Glyn Rhonwy Pumped Storage (EN010072)

Deadline 7 – Submission

10<sup>th</sup> August 2016

I provide below my comments on the Draft DCO followed separately my comments on the issues raised in the Deadline 5 submission and the Applicant's responses.

### Indicative Elevations & Section of Penstock Configuration (Revision 1)

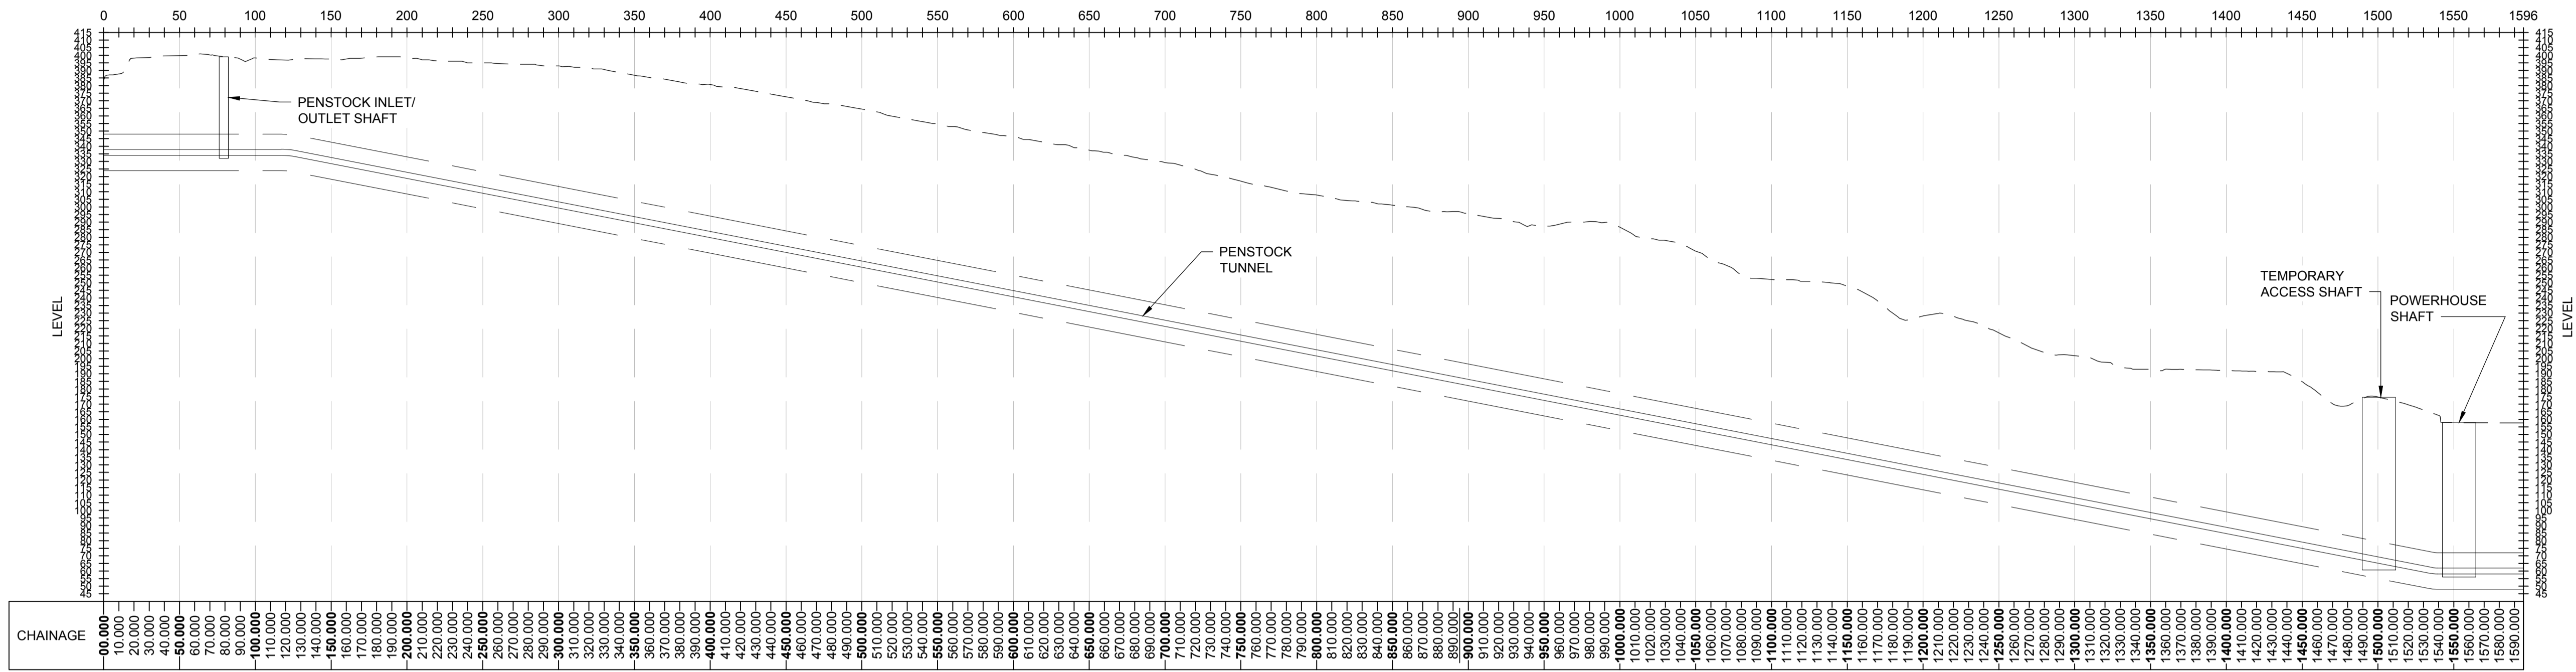
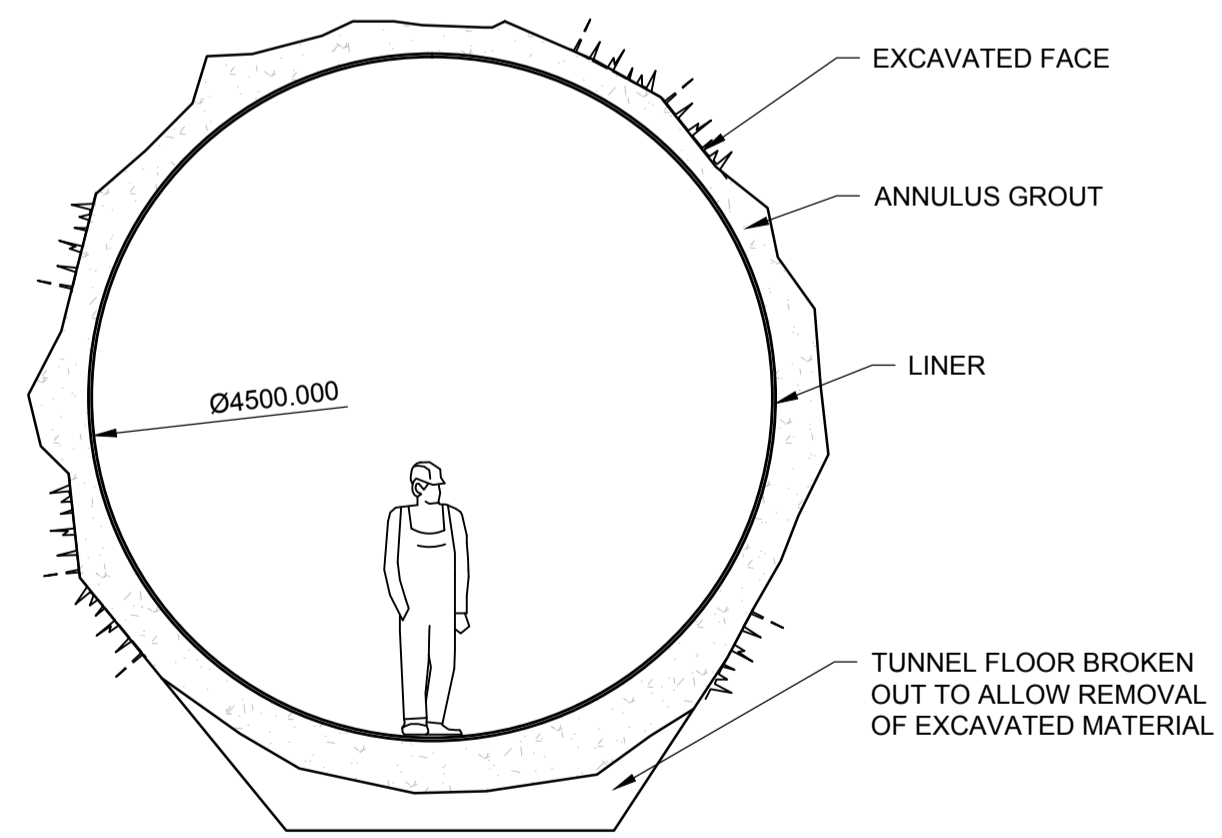
It is not the volume of excavation that is the issue here, it is the volume of shotcrete or concrete material required to restore the 4.5m finished diameter in the design. Drill look-out, overbreak and minimum concrete thicknesses will result in an overall average volume of shotcrete or concrete to be installed of over 25,000 m<sup>3</sup>. This will result in over 48,000 T of material to be imported for this activity alone. (The figure of 2.4 Tonne/ m<sup>3</sup> is normally accepted as the density of structural concrete. With cement element of 300Kg/ m<sup>3</sup> for 40N/mm<sup>2</sup> strength concrete, the remainder of the total weight is made up of water (150 Kg/m<sup>3</sup>), crushed stone aggregate (x1150 kg/m<sup>3</sup>), and sand (800 Kg/m<sup>3</sup>.)

Secondly 6,000m<sup>3</sup> is a total underestimate of the volumes of concrete and shotcrete required as this only represents an average tunnel diameter of 5.1m of tunnel. A tunnel cannot be excavated on the basis of its exact finished diameter alone. To avoid cracking and failure a minimum thickness of

250mm will be required for the reinforced concrete lining even in the low pressure sections. The face will therefore be marked for drilling at 5.0 metre diameter. The drill lookout will result in a blasted face of a further 250mm as this is necessary to accommodate the size of the drill itself on the next round. A perfectly blasted hole to suit a 4.5m diameter finished internal lining would therefore average the 5.5 m diameter allowed by the Applicant WITHOUT any consideration of the inevitable over-break. The blocky nature of slate blocky nature will result in significant over-break which, from the experience of Dinorwig could easily result in an increase radius of 300mm on average. Furthermore, a volume allowance for the excavation of the flat floor, passing places, plant and equipment recesses, and drainage will also need to be added to the volume. From a finished diameter of 4.5m the end result will be a minimum average blasted diameter , prior to any shotcrete or concrete linings of at least 6.1 metres. As confirmed by the Applicant in his responses, he has allowed only for his own unrealistic assessment of the volume of concrete required for the tunnel which fails to make ANY allowance for over-break.

This statement either demonstrates the Applicant’s fundamental lack of understanding of the processes of drill and blast tunnelling and over-break, profiling and lining operations, or shows how he glosses over the issues. The over-break in an excavated tunnel is a function of the practicalities of drilling, blasting and the rock type and condition OR Rock Mass Rating (RMR) AND not the type of lining. The use of precast concrete linings is common place in TBM bored tunnels and the equipment forms part of the tunnel ‘train’. For the precast units to be erected they must be supported by the excavated ground behind them as a 4.5m circular arch structure cannot ‘hang’ in mid-air whilst the lining is erected and concrete or grout pumped behind. In a drill and blast tunnel the broken profile will require the ‘rough’ tunnel to be pre-lined to within 25mm of the outside diameter of the precast units. However there is no point in pre-lining a low pressure rock tunnel with concrete just to enable the subsequent installation of precast concrete units. The engineering time and cost aspects of lining the tunnel mean a single operation is always preferable and the tunnel would simply be in-situ concrete lined to the finished diameter in the first place. Why do it twice? Although precast concrete units may reduce the volume of concrete BEHIND the lining the volume of imported materials, (be they aggregates, precast concrete or steel) from inside the finished lining to the rock itself, remains the exactly the same. The Applicant has failed to demonstrate how his vehicle traffic assessments are formulated and where he has allowed for each operation. It is therefore easy for him to say

However in so saying this the Examiner is afforded no opportunity to gain a true indication of the physical and resultant time scales of the penstock construction. We now have confirmation that the penstock is to be driven from the Q1 site alone. The ES had previously stated that it would be Q1, Q6 or both. The Indicative Construction Programme shows the Penstock being driven immediately following the Q6 'launch shaft', which shows that the programme is based around a TBM operation taking 1 year. It is clear that the Table 4.2 does not represent the programme or sequence of events that will happen with a drill and blast approach now proposed by the Applicant which will take the best part of 20 months from Q1.

*Page 5-21 "The Applicant has deliberately not shown the thickness of concrete lining as this will, indeed, vary over the penstock length and be dependent on a number of variables including rock characteristics and final penstock lining design."*
